Application no: **3/2023/0126**

Address: **Bent House Longtons Lane Tosside BD23 4SU**

Proposal: **Proposed change of use of part of site to eco-retreat, wellness re-wilding centre.**

The Local Highway Authority have viewed the plans and highway related documents and have the following comments to make:

Drawing Title
PROPOSED SITE PLAN

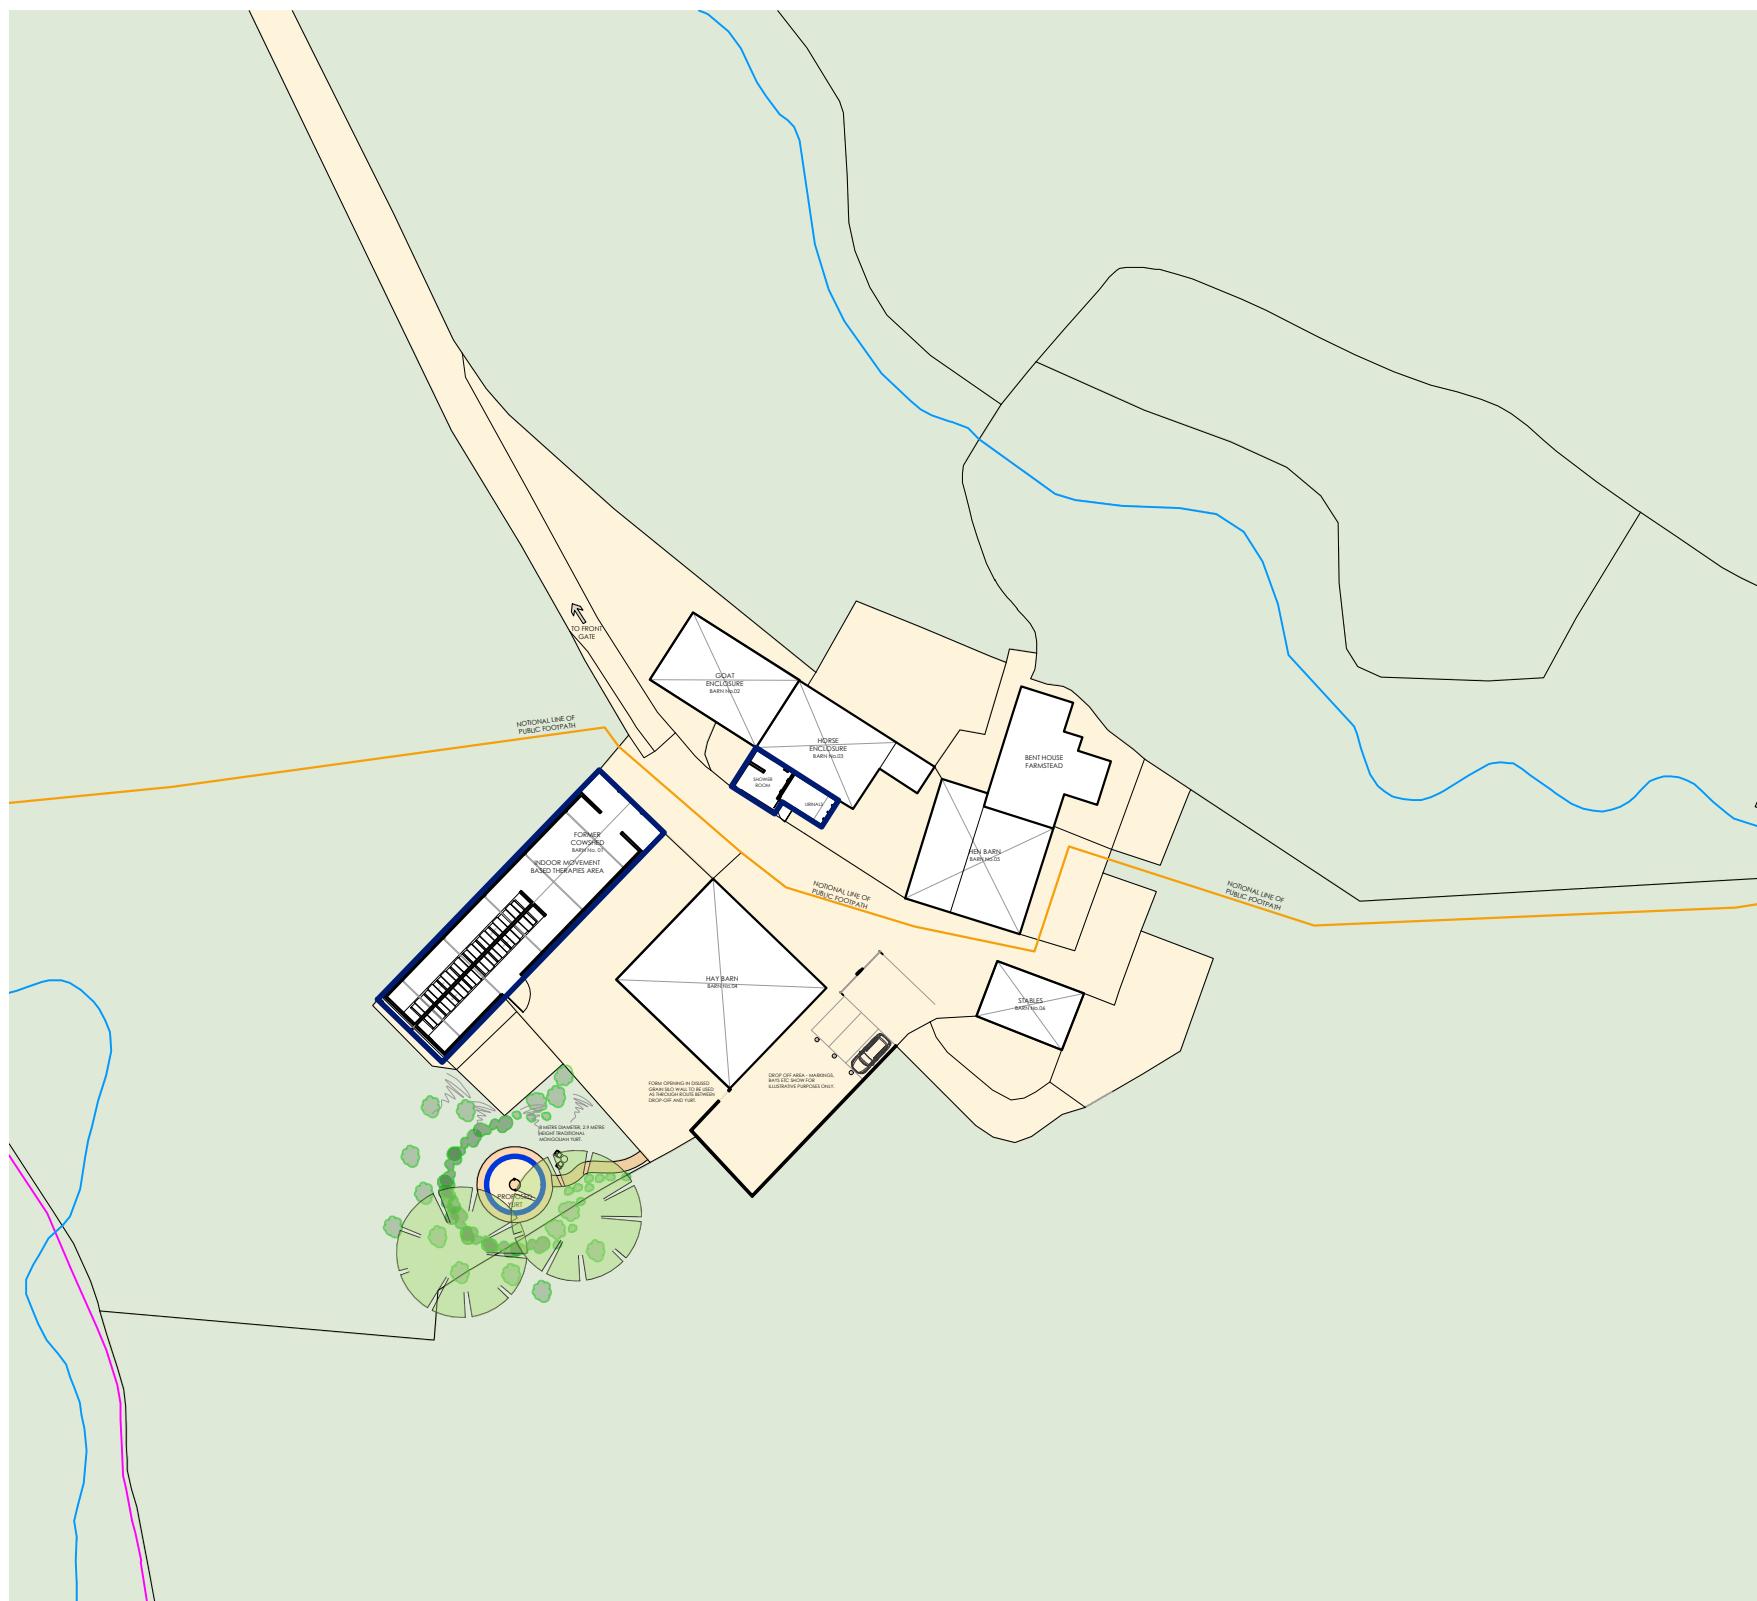
The LHA have reviewed SPA drawing number 6681-S02B titled "Proposed Site Plan" and are aware that 3 car parking spaces will be provided. The LHA have no comments to make regarding the quantity of parking with it being adequate given that the site has ample space for one staff member and the drop off/ pick up vehicle.

6. The development hereby permitted shall not be occupied until such time as the parking and turning facilities have been implemented in accordance with SPA drawing number 6681-S02B. Thereafter the onsite parking provision shall be so maintained in perpetuity.
